Ref: 12/303/PA

31 July 15

Proposed Extensions and Alterations to Marriott's Farm, Blackhole Drove, West Pinchbeck for Mrs E Withers – Condition Compliance

JOINERY DETAILS 1:10

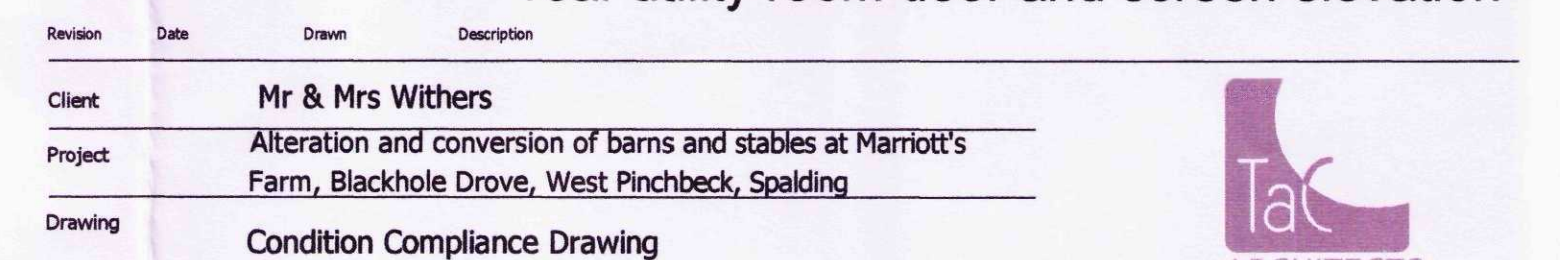
2. Condition 4 – It was agreed that the central mullion members in glazed doors would be removed and the application drawing will be amended accordingly. Other issues raised concerning top and bottom rails, window section dimensions and thinner glazing were agreed as being satisfactory as drawn, and the condition will be discharged on this basis..

Finally, I enclose a copy of the revised drawing numbered 12/303/PA/ 005A showing the revisions to glazed doors.
